From: Kevin Eaton [REDACTED]
Sent: 10 December 2021 15:40
To: Kathryn Welch <Kathryn.Welch@arun.gov.uk>
Subject: Re: Flint Barn K/49/21/HH

02
2002 **PROPOSED 1ST FLOOR PLAN**
Scale: 1:50

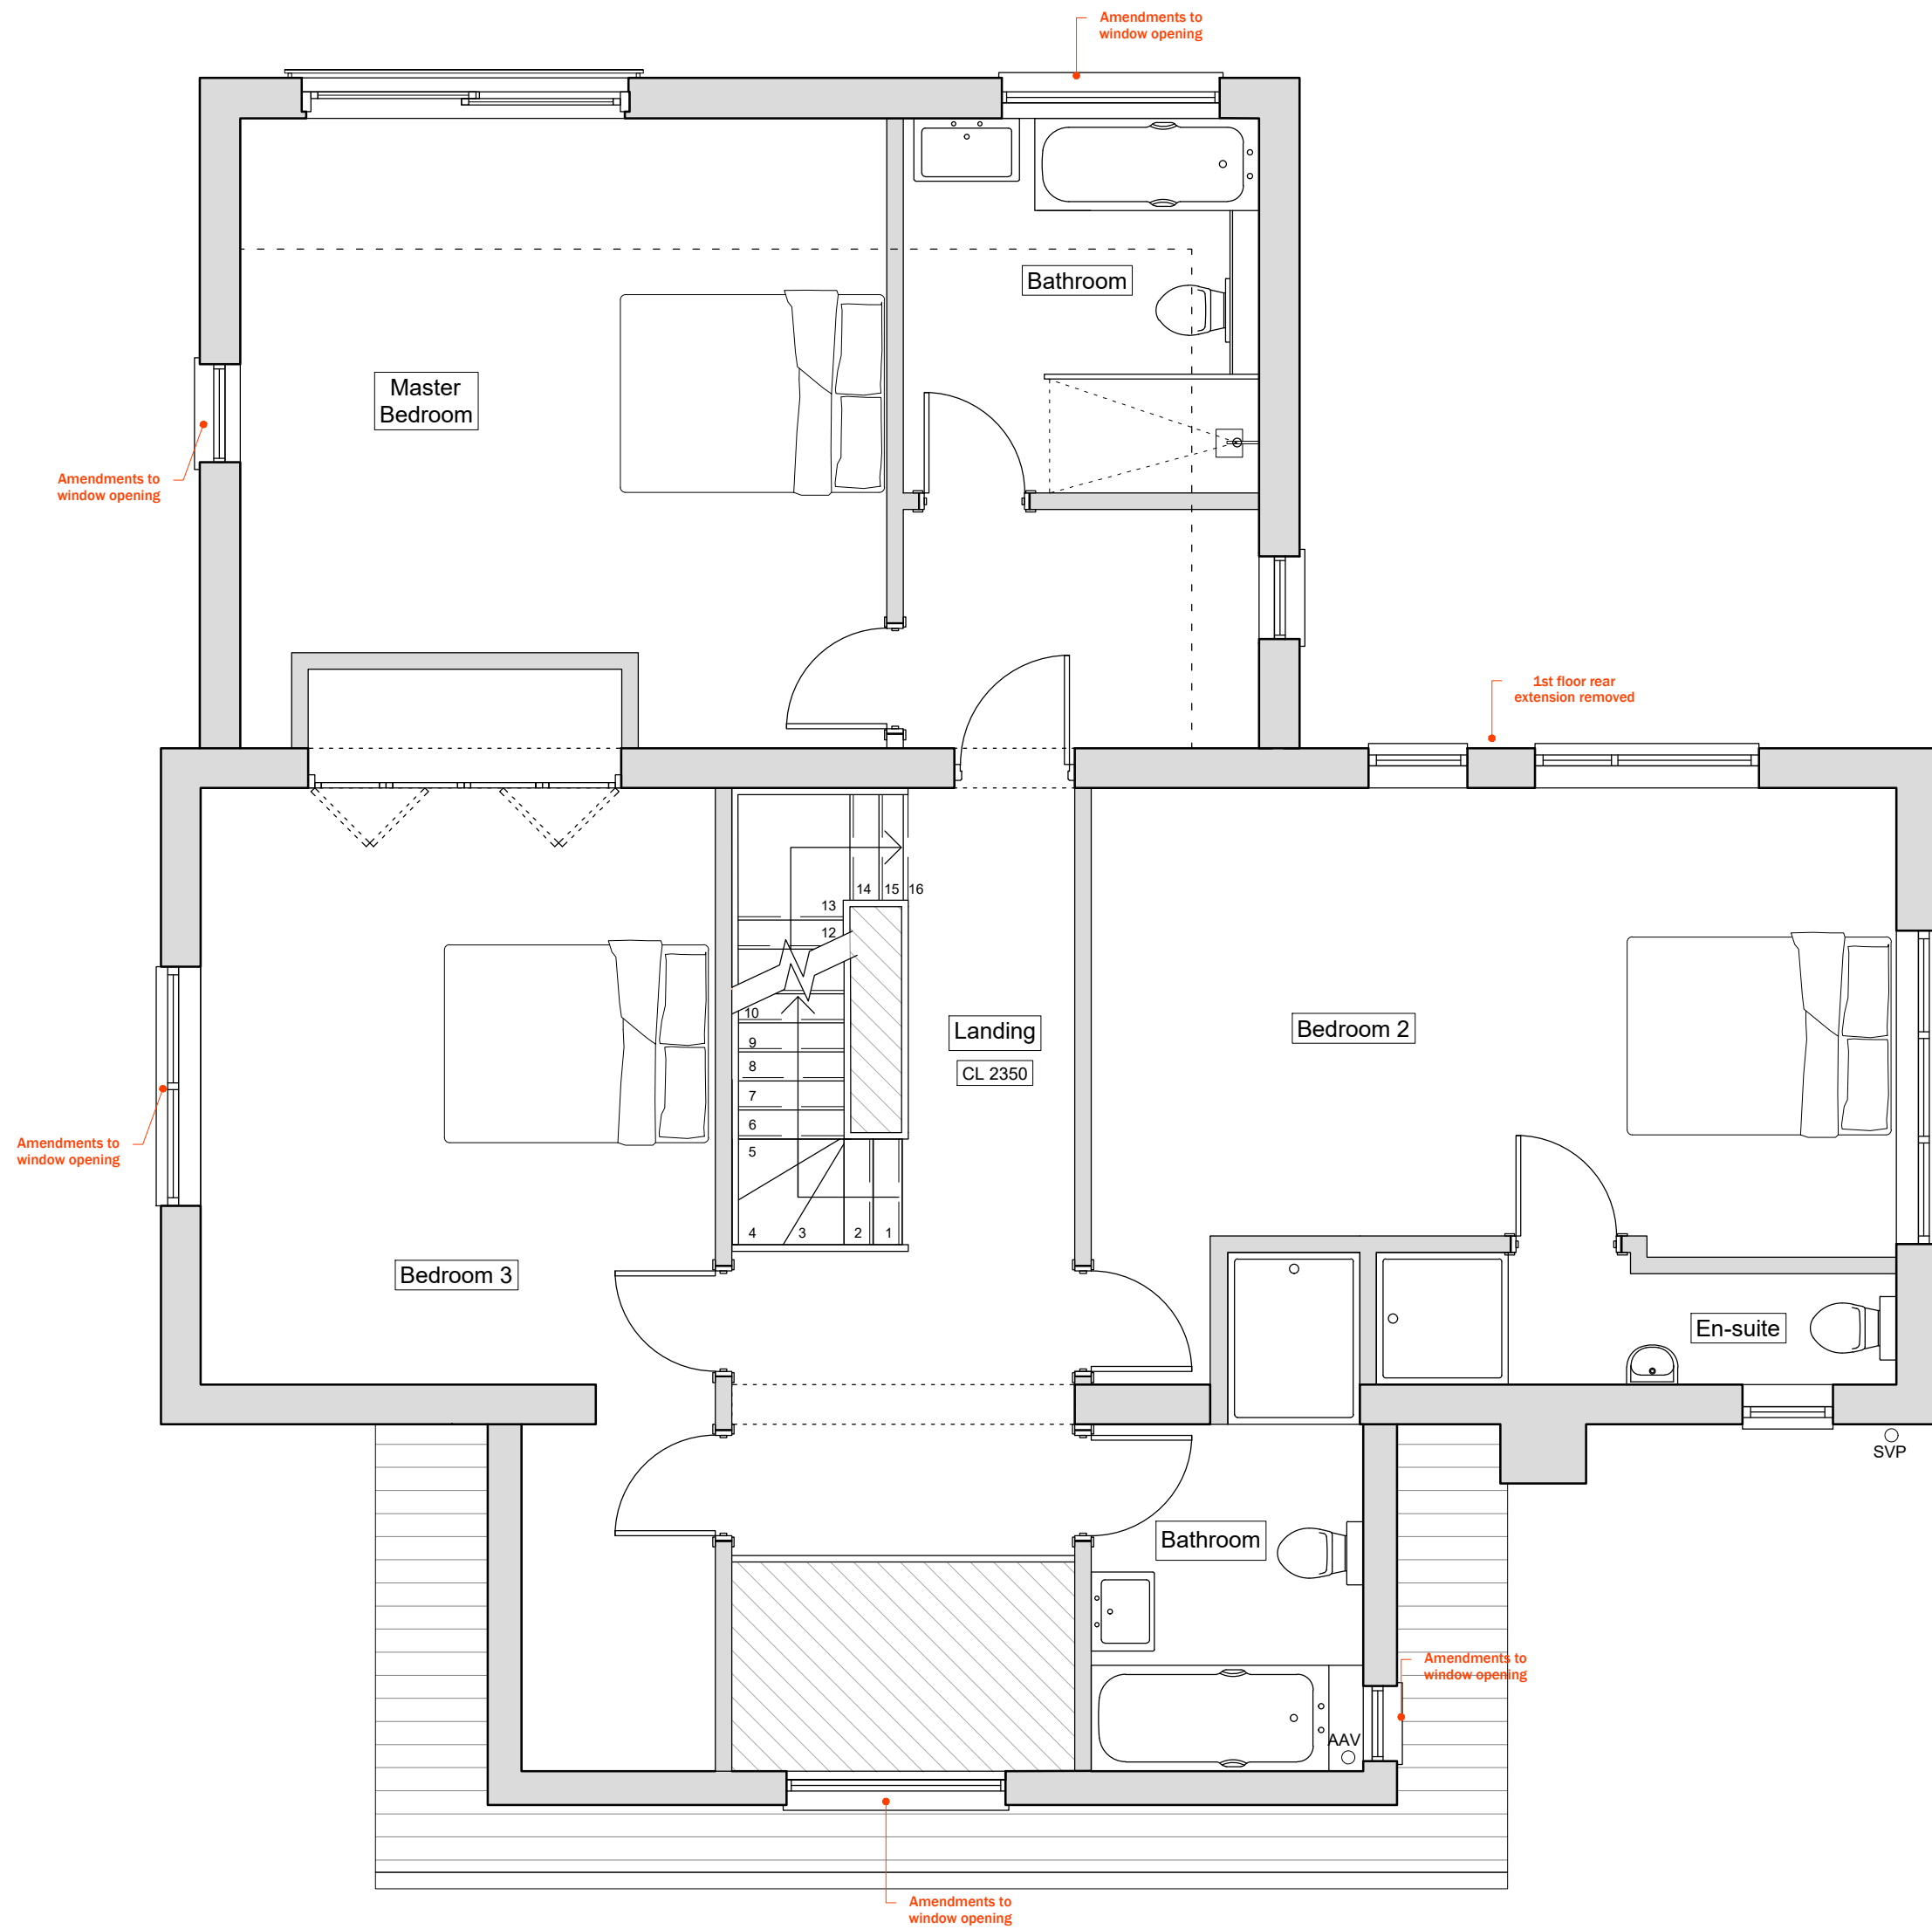
I would be grateful if you could amend the plan showing the juliette balcony on the eastern elevation to bedroom 3, if this is what is going to be/has been built.

Further to your e-mail below I have requested a revised plan drawing showing the Juliet balcony from my architect. As soon as I receive this I will forward it to you.

In the meantime I have annotated the existing drawing to show the balcony (although I cannot guarantee the accuracy of the scale). This is attached at the end of this e-mail.

02 PROPOSED NORTH ELEVATION
2004 Scale: 1:50

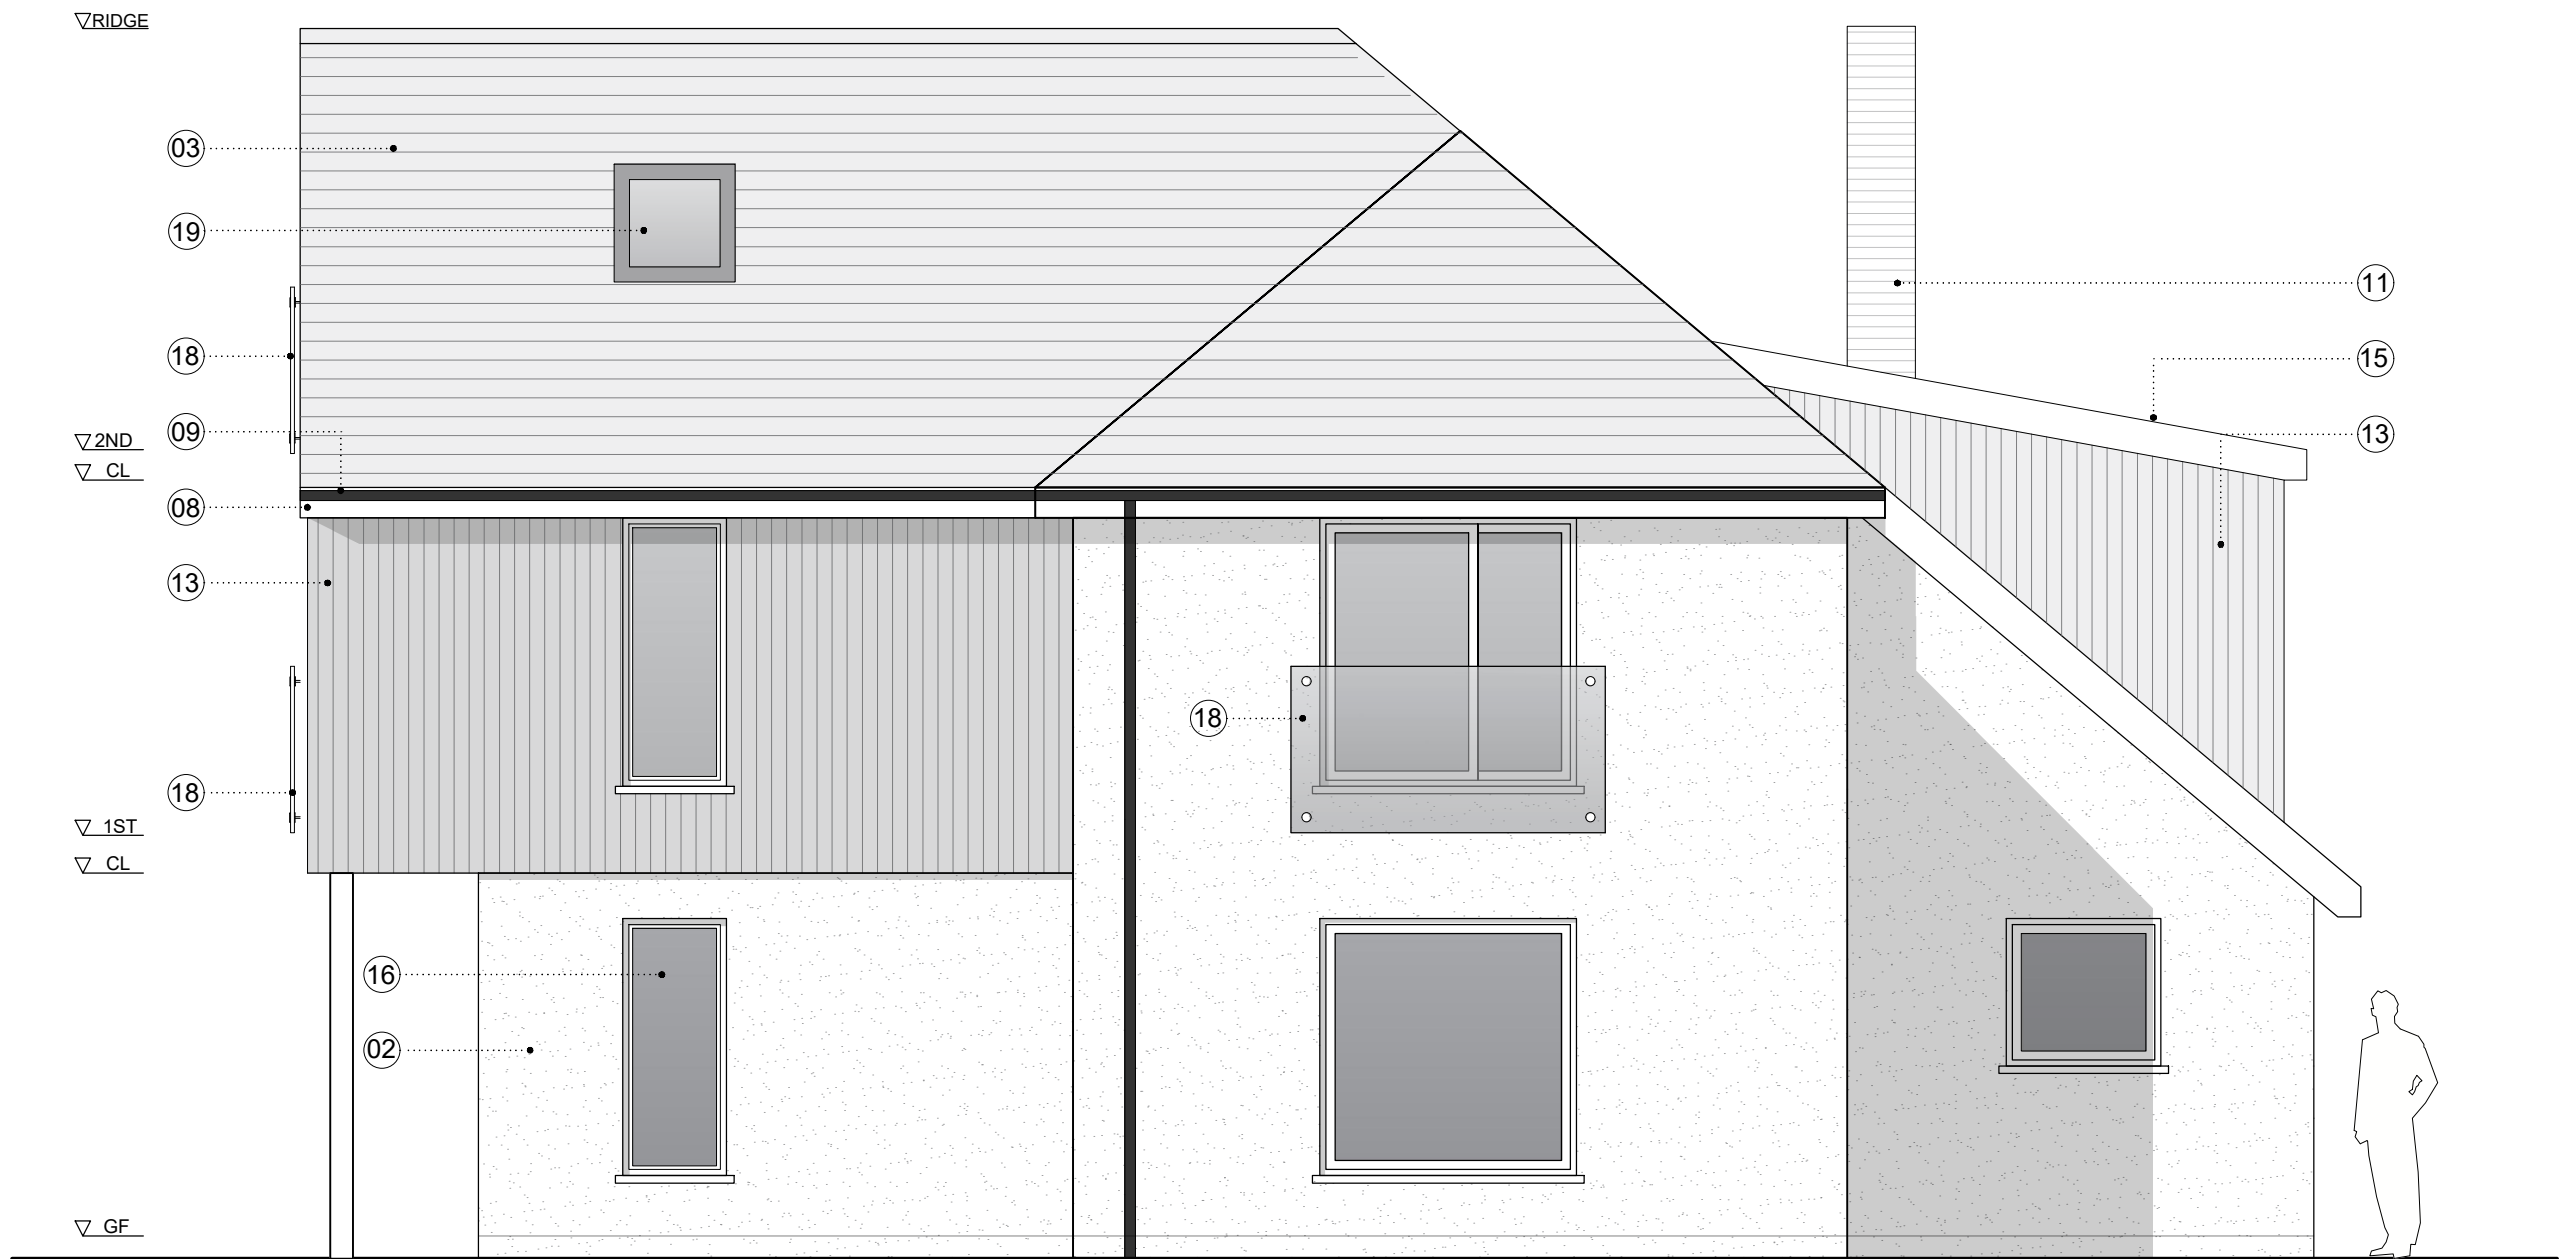
I would also be grateful if you could summarise the differences between the current application and the already approved scheme i.e. dormer to northern elevation higher than approved, just so that I can focus my work on the relevant areas.

A - Front (North) dormer - The 'as-built' dormer is approx' 350mm higher than the original (application). The current application was submitted primarily to regularize this non-compliance with the original approved proposal.

D - Roof Covering to new (North) dormer - As built roof covering is a folded lead effect GRP roof finish. This was originally a clay tile roof covering in the approved plan but due to the change in roof pitch on the 'as-built' dormer (see A), the tile was not compatible - hence the necessity to change the design and material.
